Your Ref:
Our Ref: A/78/09/
Please ask for:
Mrs A Gardner

27th August 2009

Outline application for terrace of 4 no. 2 bed houses - resubmission following A/75/08/
101 Lloyd Goring Close & land to rear of 7-15 Lansdowne Way Angmering

LAYOUT PLAN 1/200

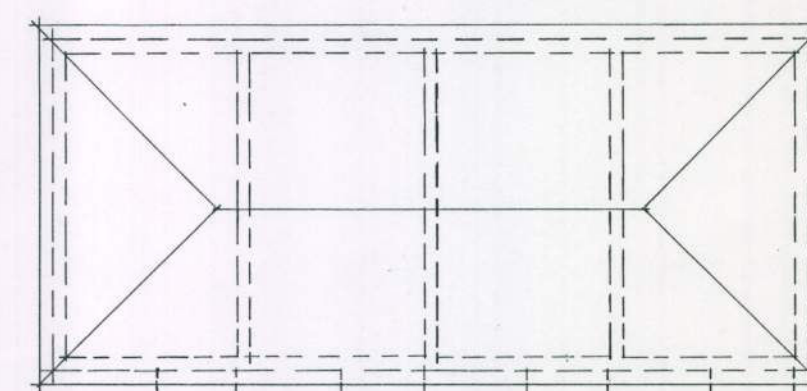
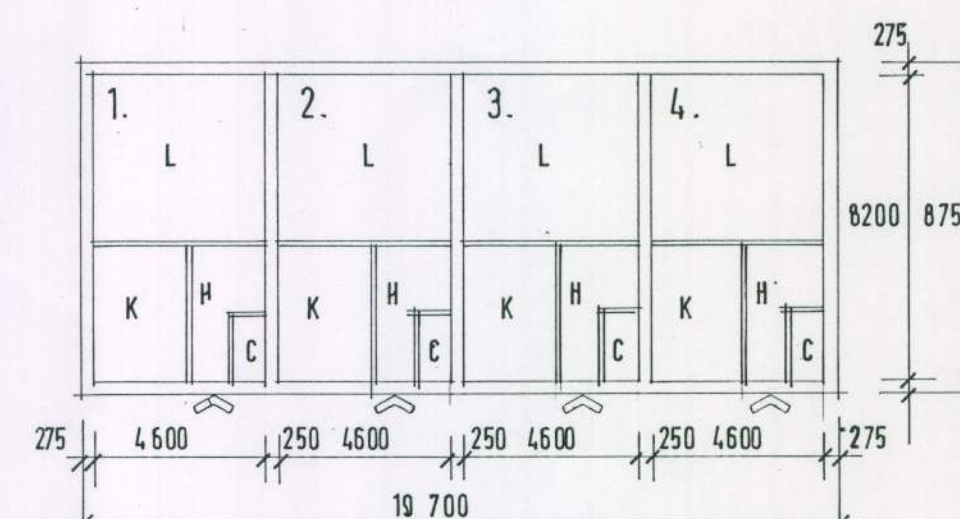
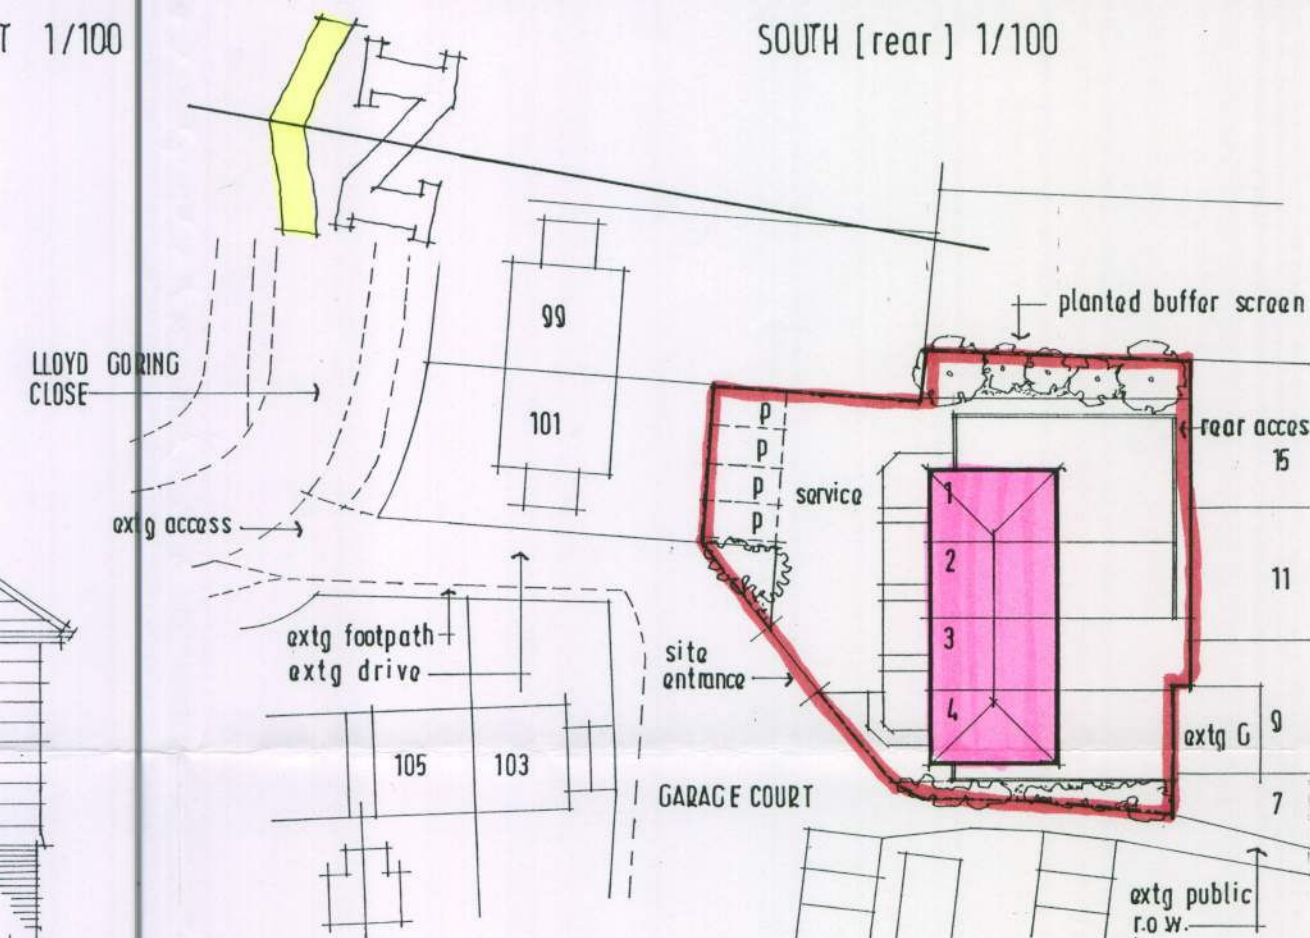
We consider the application has some merits but is in our view still an overdevelopment of the site in respect of the number of housing units and the affect on the rest of the area with regard to parking, traffic and overlooking neighbours. ☐

The orientation of the terrace has caused the bedroom windows to be overlooking a number of adjacent properties and when reviewing the previous application on this site we consider the direction of the buildings in that application was better suited. ☐

It is our view that if a terrace of 3 houses (presuming the internal sizes remain the same) in the previous applications orientation (A/75/08) would overcome this issue and provide more space within the site for parking and turning. ☐
